Development Facilitation Team (DFT) – Review Comments

DRB Project No: PR-2023-008364 Date: 04/12/2023 Agenda Item: #6 Zone Atlas Page: (R-15, S-14, S-13, T-13, T-14)

Legal Description: TRACTS 6A AND 6B, REPLAT OF TRACT 6 BULK LAND PLAT TRACTS 1-15, MDS

Application For: SD-2023-00084--PRELIMINARY/FINAL PLAT (DHO) Sketch Plat 3-15-23 (DFT)

**PLAT OF  
TRACTS 6A and 6B**  
BEING A REPLAT OF TRACT 6 OF BULK LAND PLAT  
TRACTS 1 - 15, MESA DEL SOL  
SECTIONS 20, 29, 30, 31 and 32  
TOWNSHIP 9 NORTH, RANGE 3 EAST N.M.P.M.  
CITY OF ALBUQUERQUE  
BERNALILLO COUNTY, NEW MEXICO  
MARCH 2023

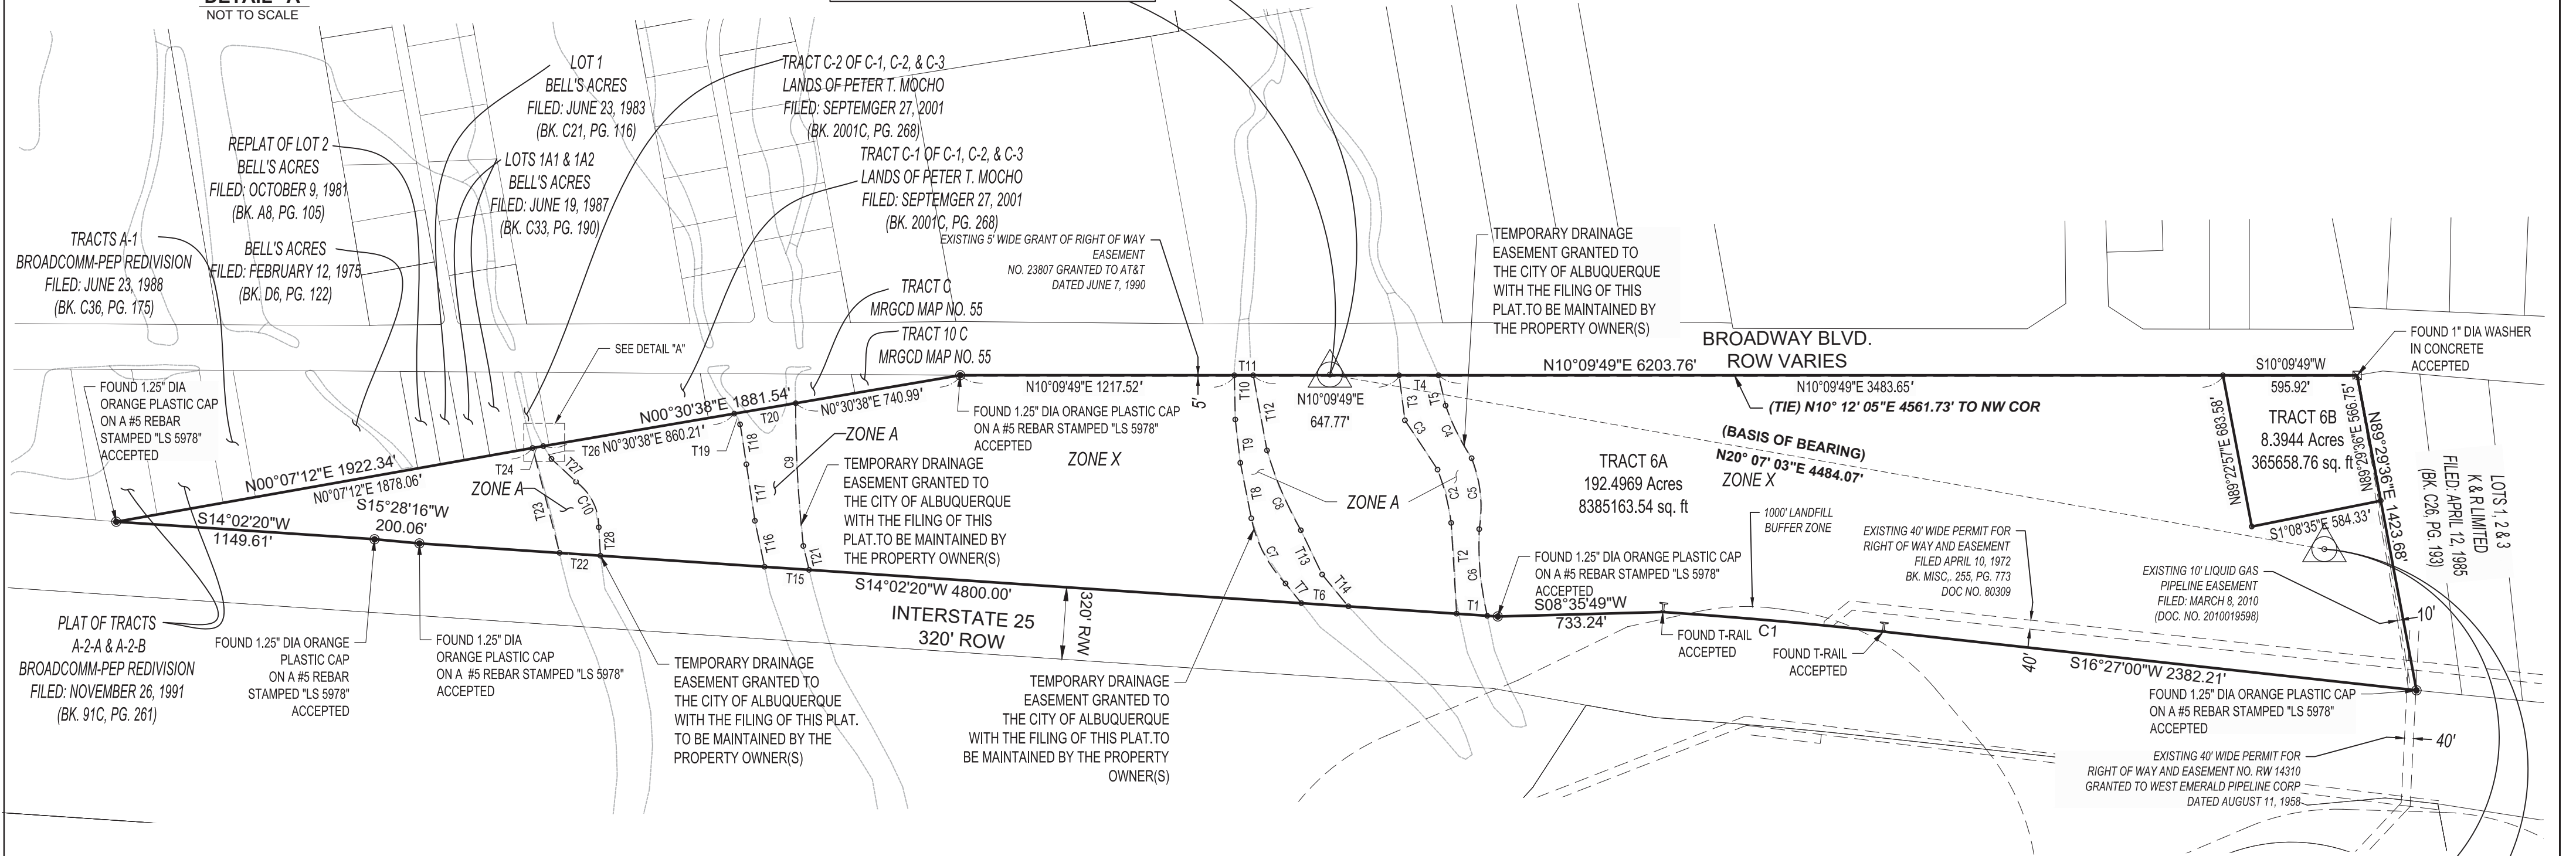
1. Please add the following note:

- a. Public water and public sanitary sewer infrastructure is currently unavailable for the subject site and any future service will require the extension of public water and public sanitary sewer infrastructure. The site is determined to be for the use of a PNM sub-station and is not seeking service.
- b. For future service, request an availability/serviceability statement online at the following link www.abcwua.org/Availability_Statements.aspx. Requests shall include fire marshal requirements.
